City of Portland, Maine - Building or Use Permit Application

Permit No: 04-1307	Issue Date: NOV 12 2004	CBL: 428 J001001
-----------------------	----------------------------	---------------------

Location of Construction: 223 Sherwood St	Owner Name: Cummings Eric J	Owner Address: 223 Sherwood St	Phone: CITY OF PORTLAND
Business Name:	Contractor Name: Eric Cummings	Contractor Address: 12 Critter Dr Windham	Phone:
Lessee/Buyer's Name	Phone:	Permit Type: Alterations - Dwellings	Zone: R-5

Proposed Use: single family replace existing foundation interior renovations including closet	Proposed Project Description: replace existing foundation interior renovations including closet by taking out one and making another closet into two closets
---	--

FOUNDATION PLAN

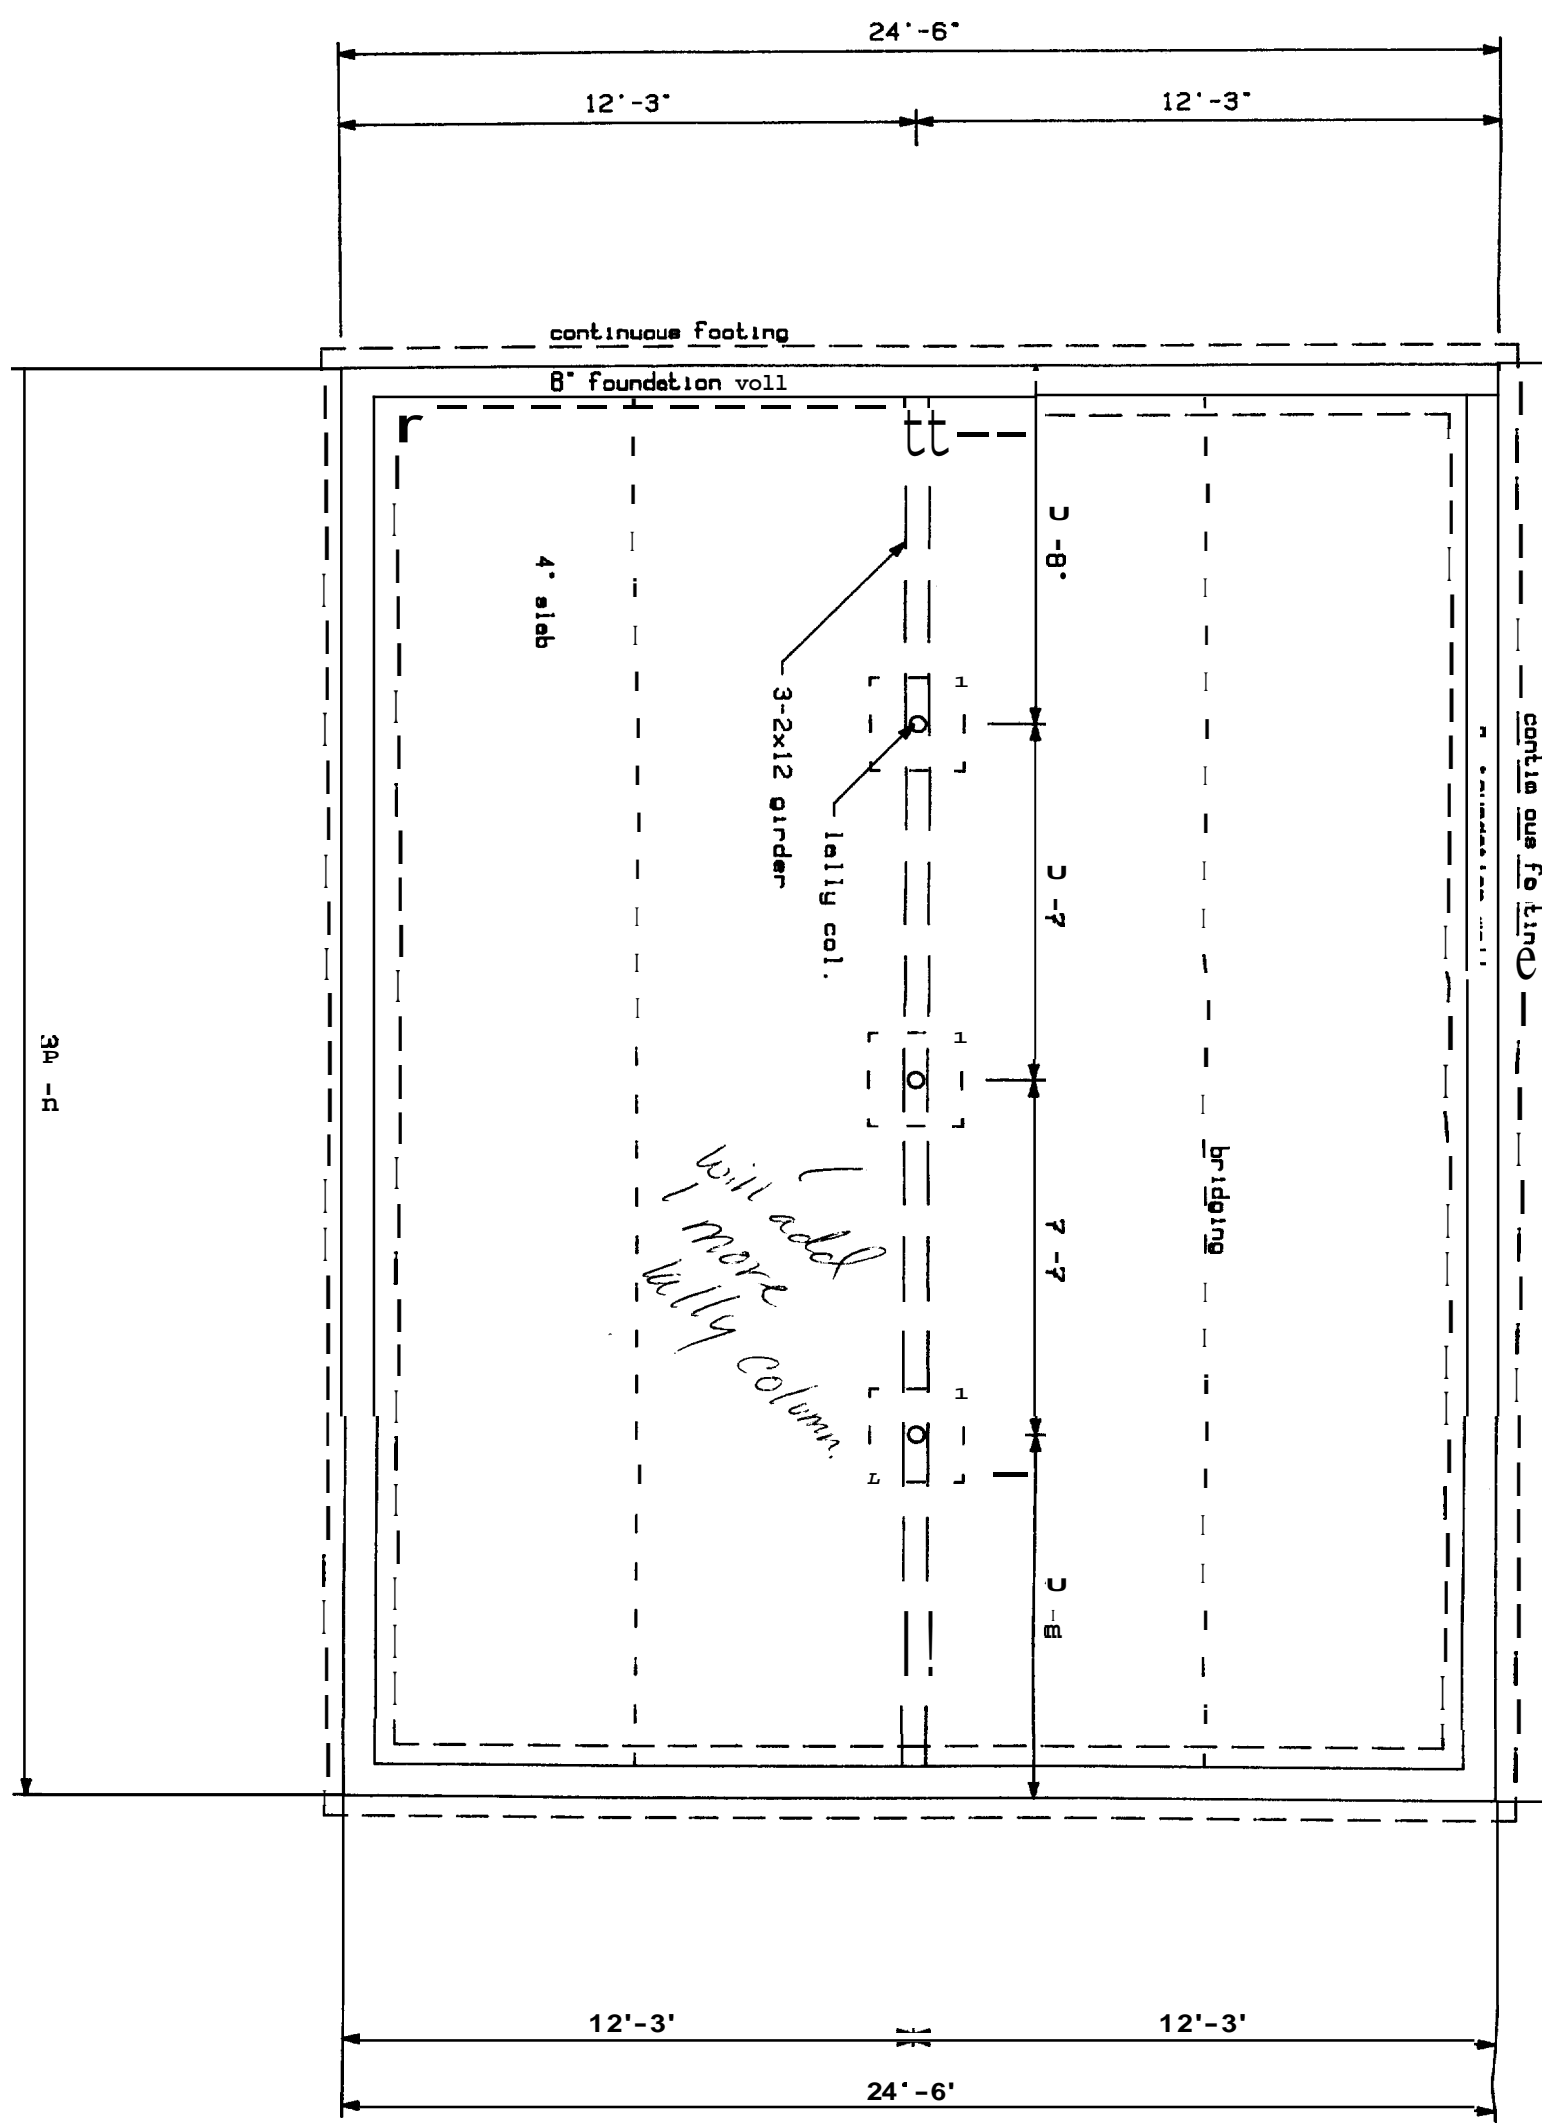
9/23/04-tmm: need cross section of foundation, anchor bolt size and spacing, will the elevation of the house be raised, and is the wall bearing that is being removed? Left message w/owner.

11/2/04-tmm: rec'd plans 11/01/2004 - left message w/owner - need footing size, bolt spacing, need on emore lally column so spacing is 6'oc.

Need 5/8" rebar
 Bolt 5/8" diameter
 Footing 5/8" diameter
 size

- 1) Permit approved based on the plans submitted and reviewed w/owner/contractor, with additional information as agreed on and as noted on plans.
- 2) Frost protection must be installed per the enclosed detail as discussed w/owner/contractor.
- 3) Separate permits are required for any electrical, plumbing, or heating.
